**Subject:** BL-25-00022 Bonafair-Bugni - Notice of Application

**TO:** All Staff  
**FROM:** Public Works Plan Review Team  
**DATE:** December 08, 2025  
**SUBJECT:** BL-25-00022 Bonafair-Bugni

# RECORD OF SURVEY

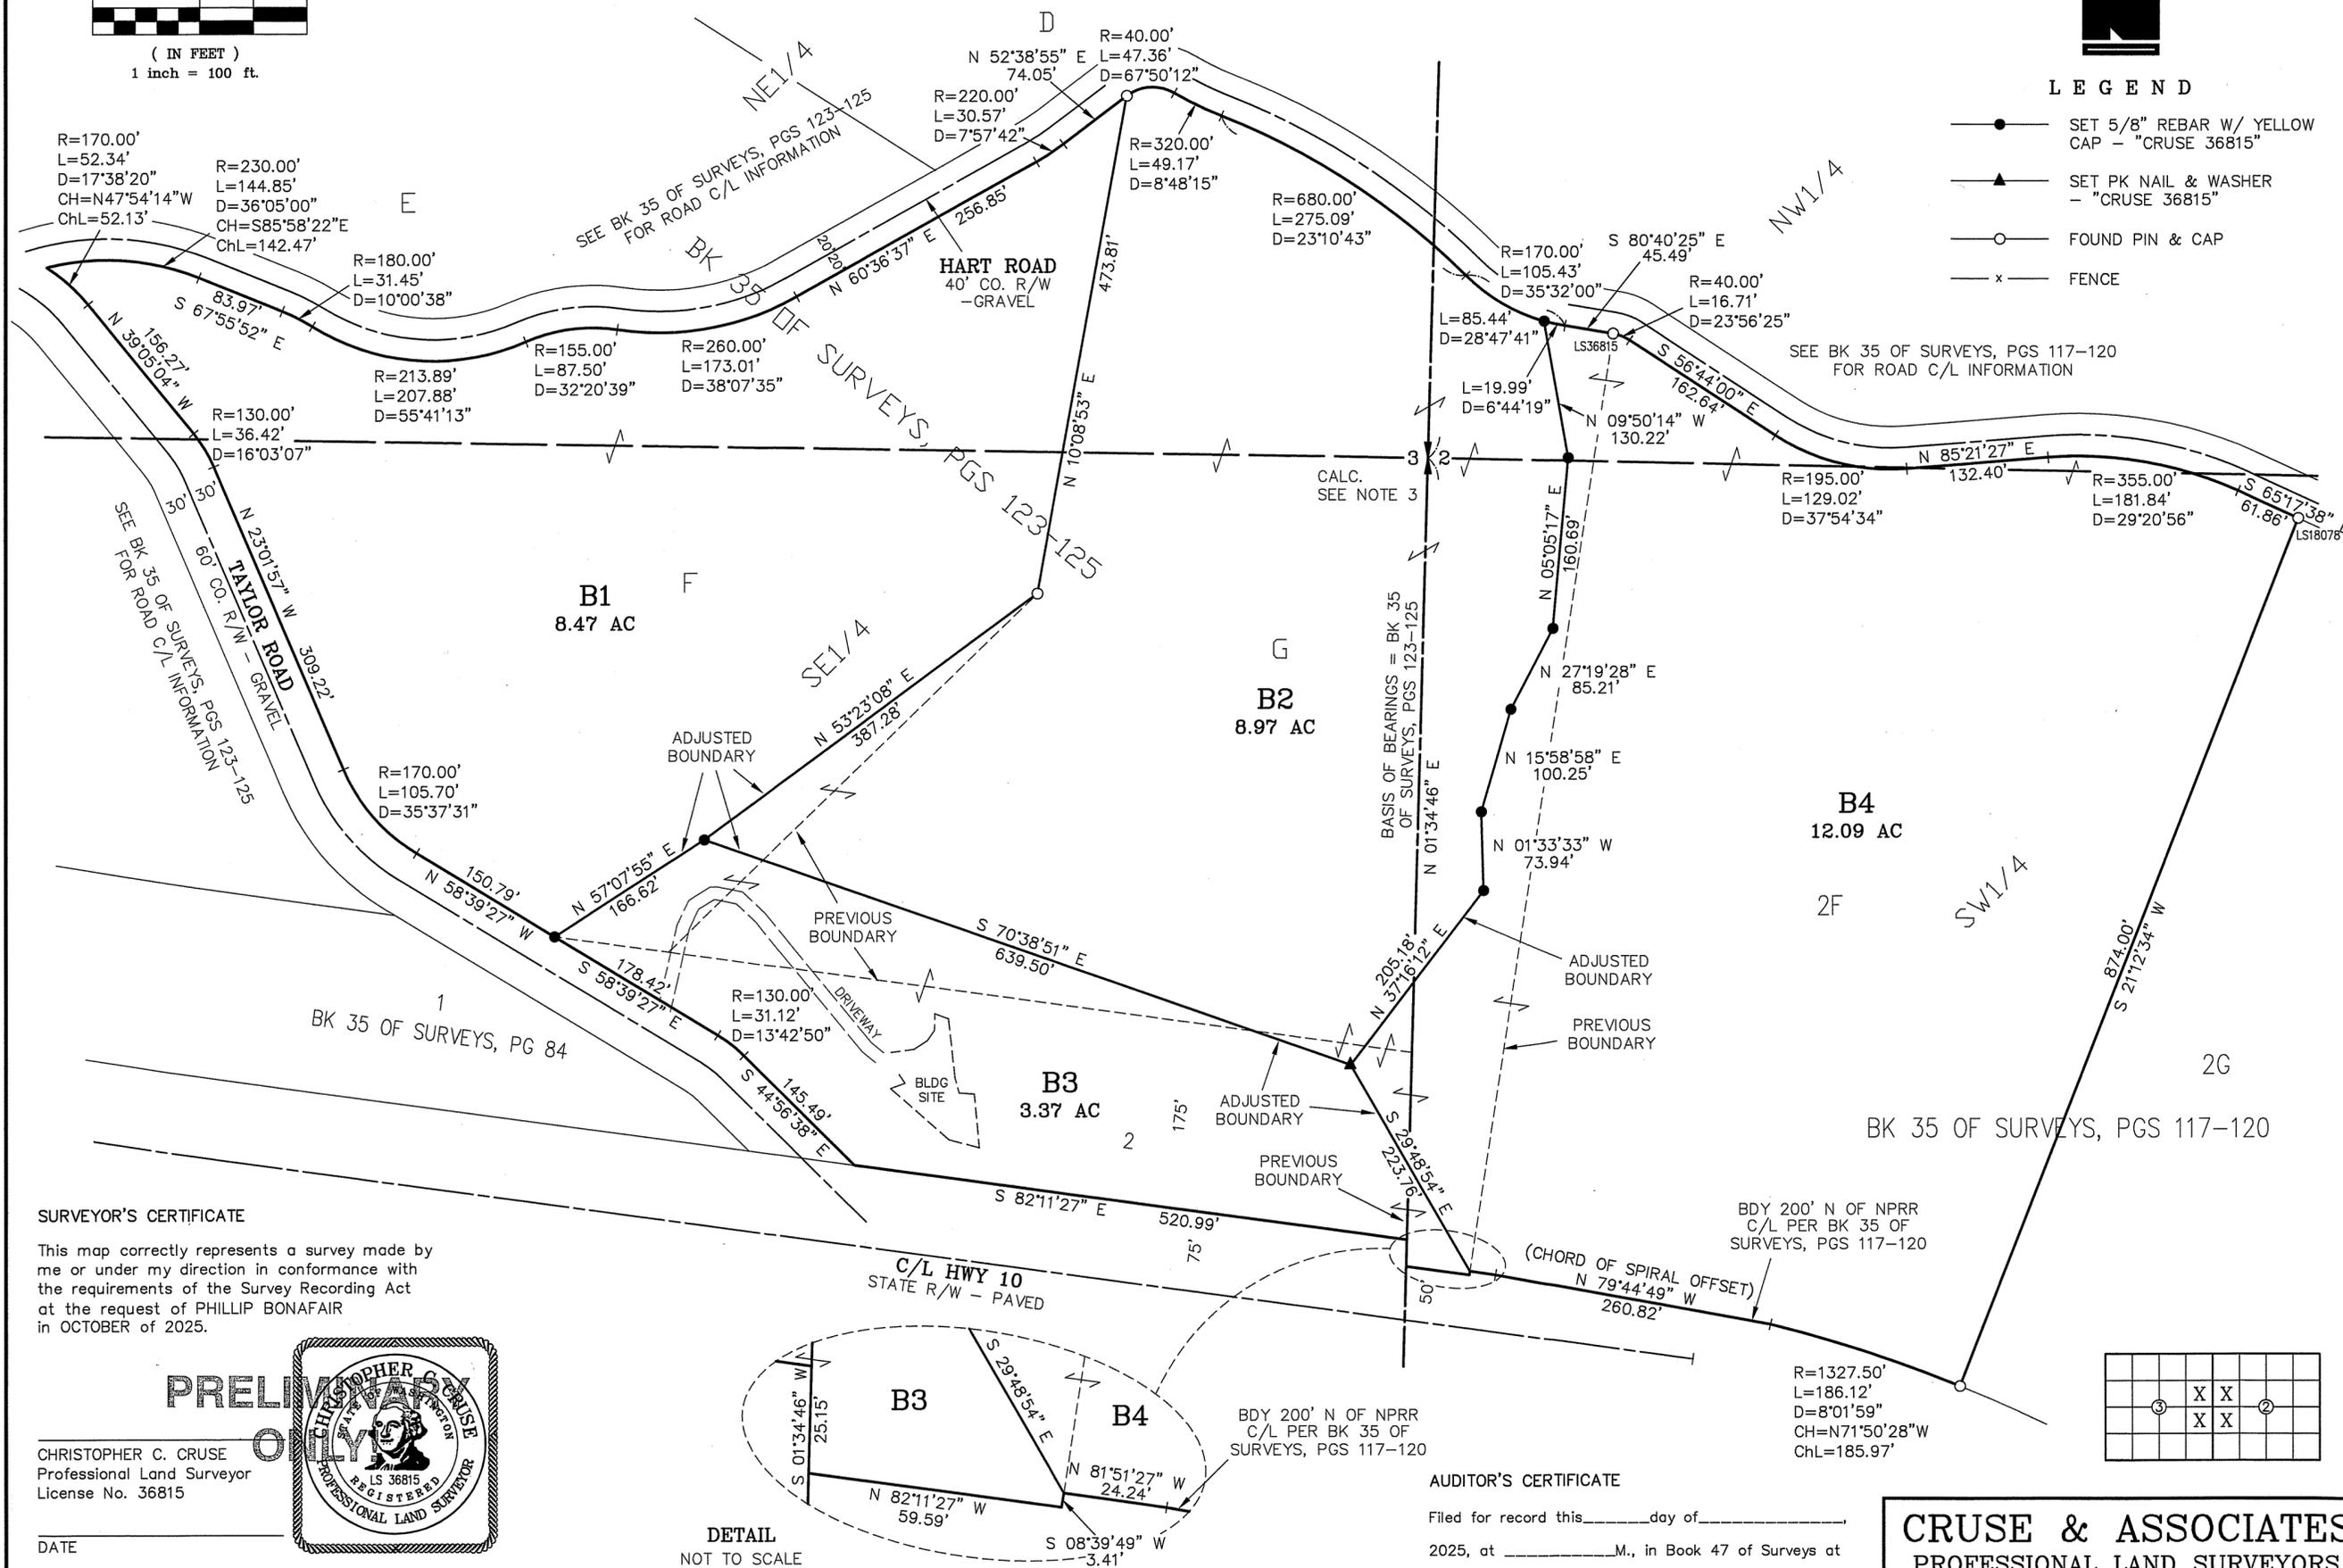
| <b>SURVEY</b>                     | <p>The final submittal must address the following elements of the survey map:</p> <ol style="list-style-type: none"> <li>1. Please identify ownership and surfacing for Hart Rd, Taylor Rd and Highway 10.</li> <li>2. Please label the line of Hwy 10 (Lw Line? Center line?)</li> <li>3. The south line of Parcel B4 includes a line labeled "(Chord)". This should be clarified. Is this the chord of a spiral offset or a circular curve. It should be clear that the arc is the boundary of the parcel and the chord line isn't. If there are particular complexities about this line and the record information it was derived from, it could be addressed via a note. (JT)</li> </ol> <p>OF NOTE<br/>         Lot closures have not been reviewed at this time.</p> |
